REQUEST

Current Zoning: R-17MF(CD) LLWPA (multifamily residential, conditional, Lower Lake Wylie Protected Area)
Proposed Zoning: NS LLWPA (neighborhood services, Lower Lake Wylie Protected Area)

Approximately 1.61 acres located north of Dixie River Road, just west of Shopton Road.

The petition proposes to rezone a vacant parcel to allow for a daycare facility with associated parking and playground area.

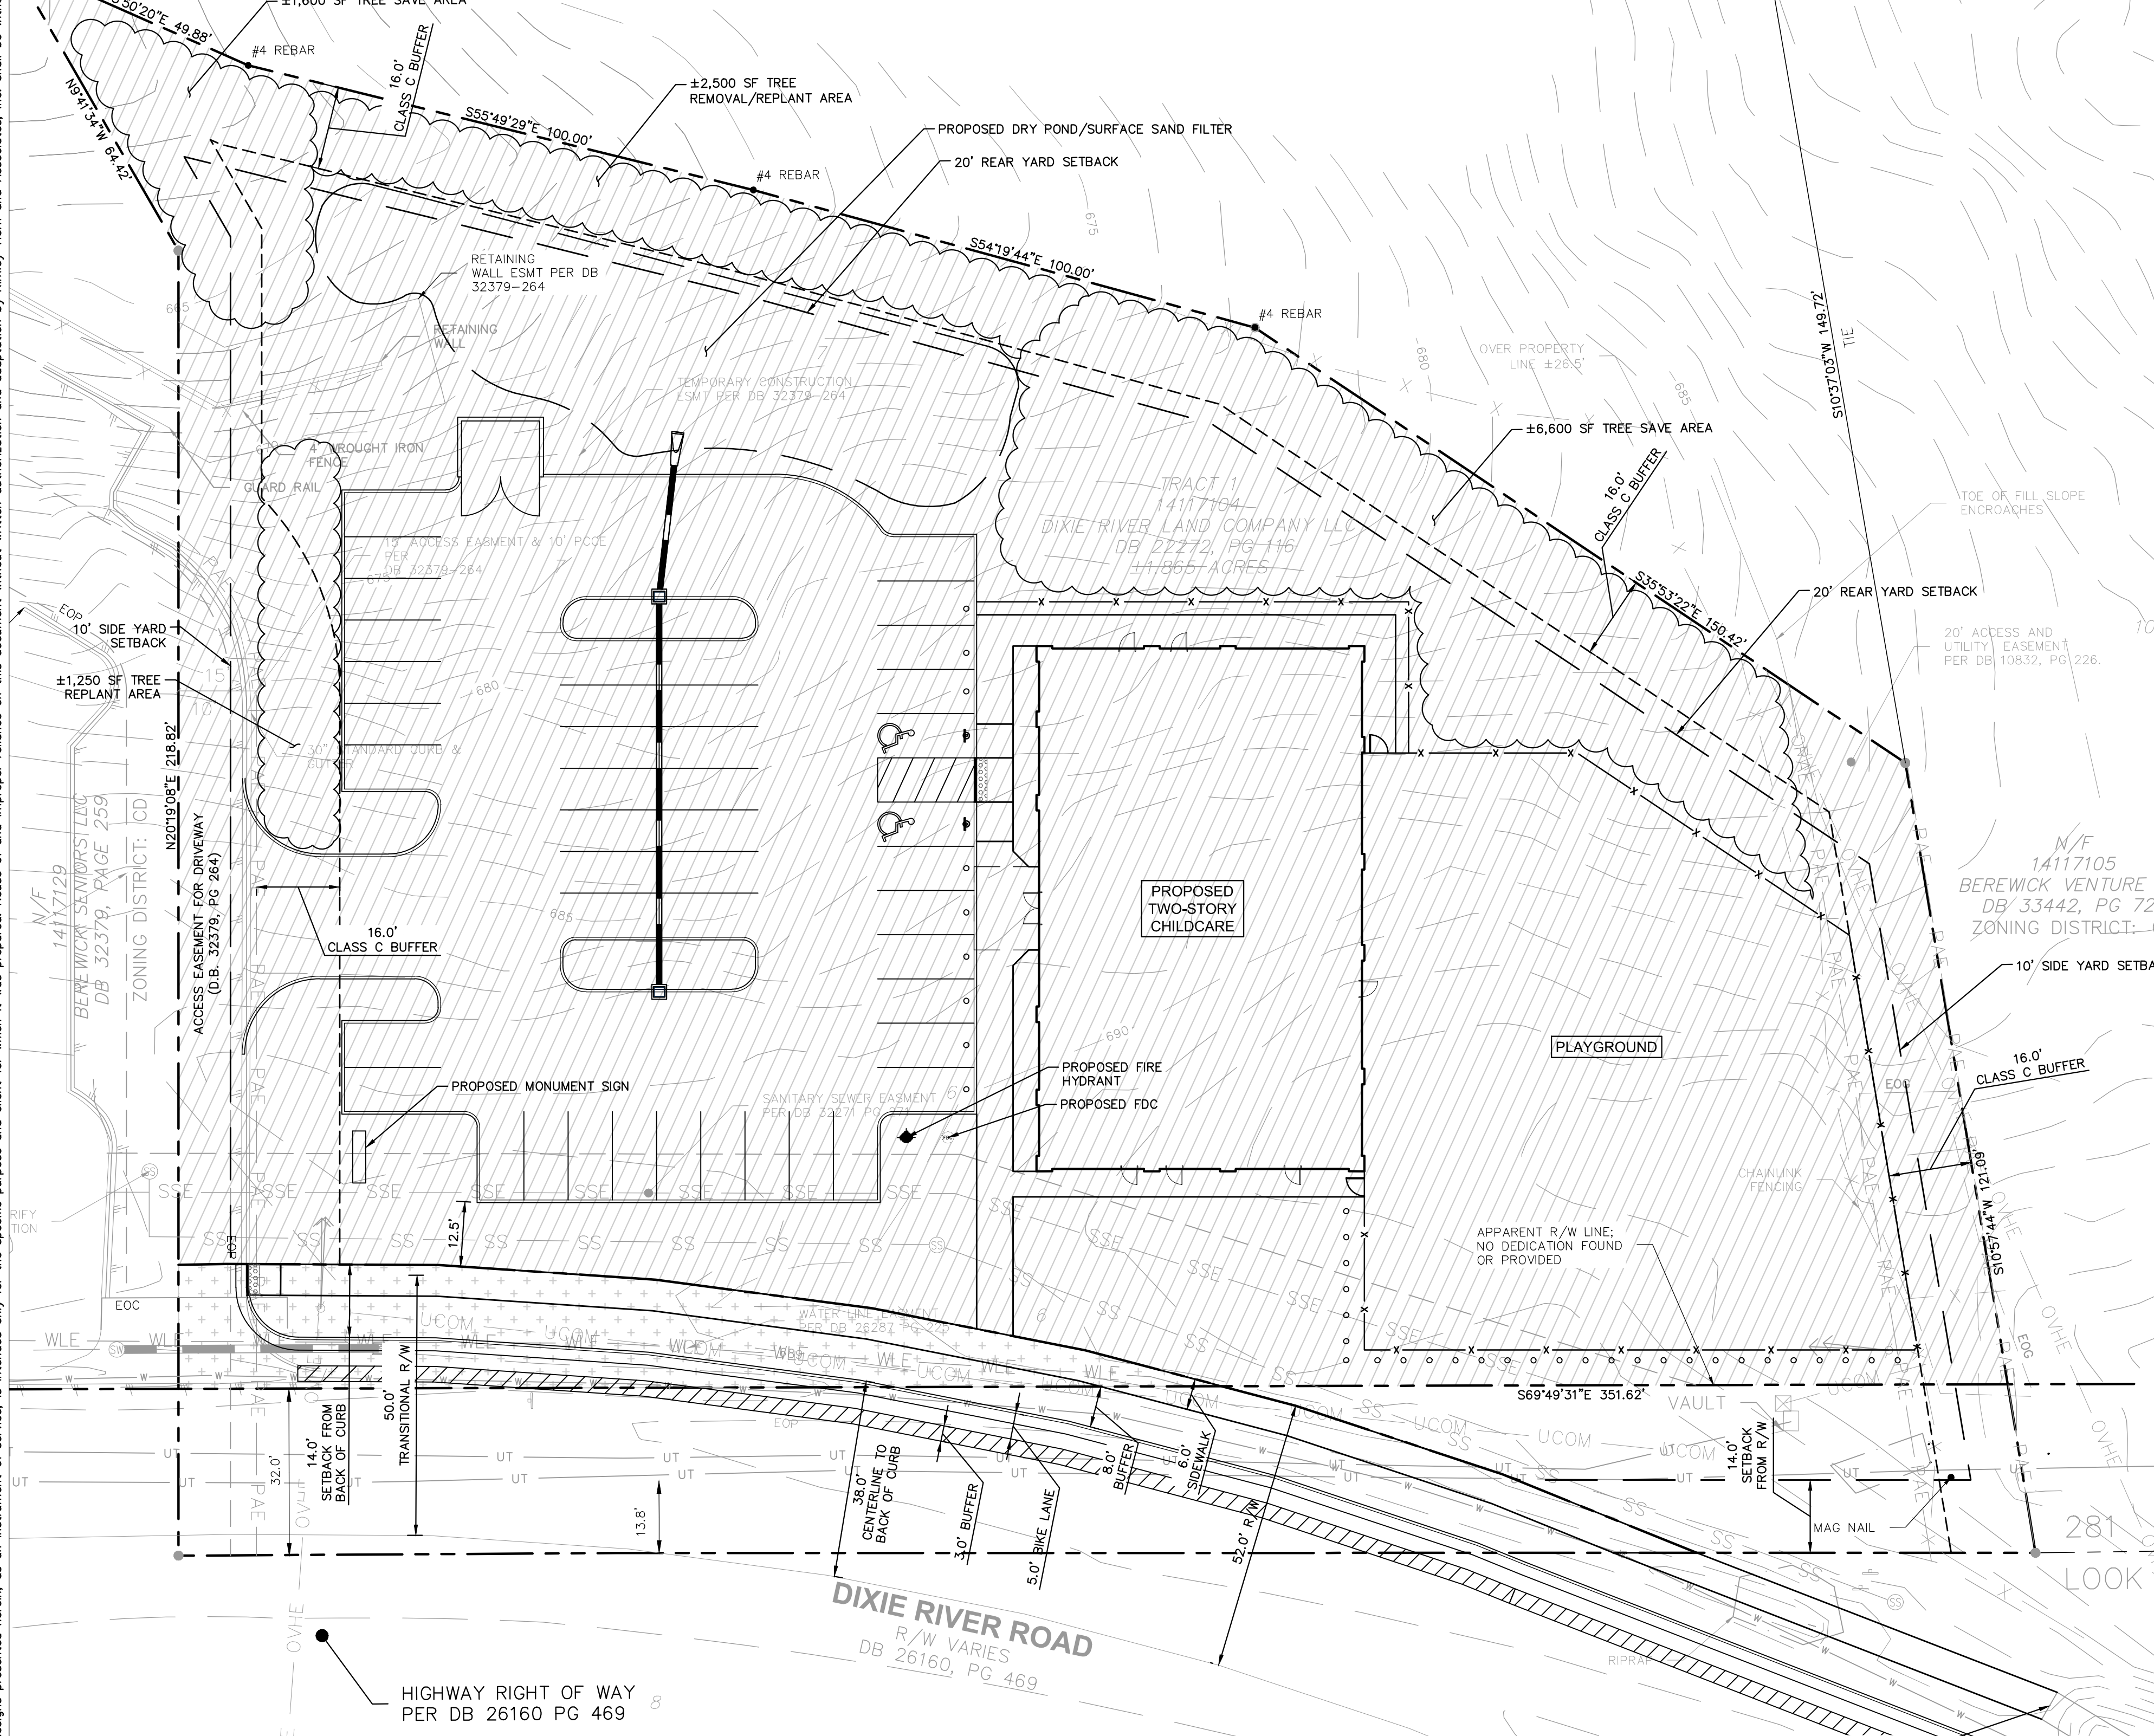
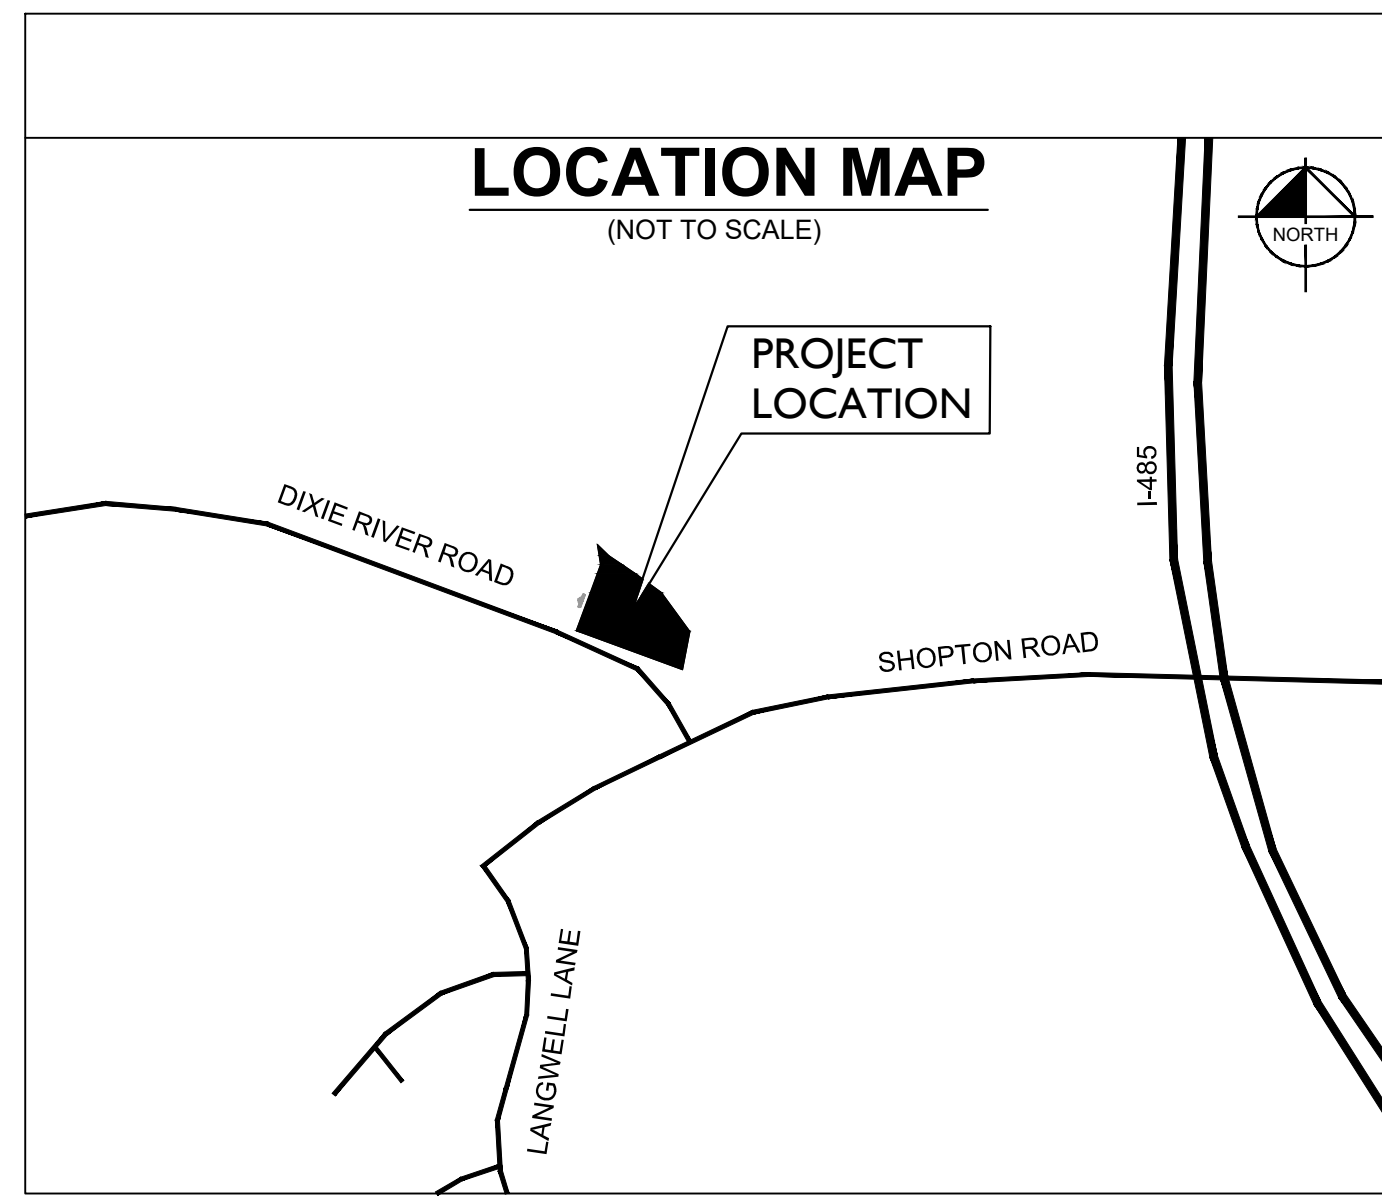
1. ~~Add LLWPA (Lower Lake Wylie Protected Area) to both the existing zoning and proposed zoning on the site plan.~~ **ADDRESSED**
2. ~~Remove notes 3.1 and 3.2 relating to NS uses. They are in conflict with note 3.2.1 and the labeling of the building on the site plan as "proposed two-story childcare".~~ **ADDRESSED**
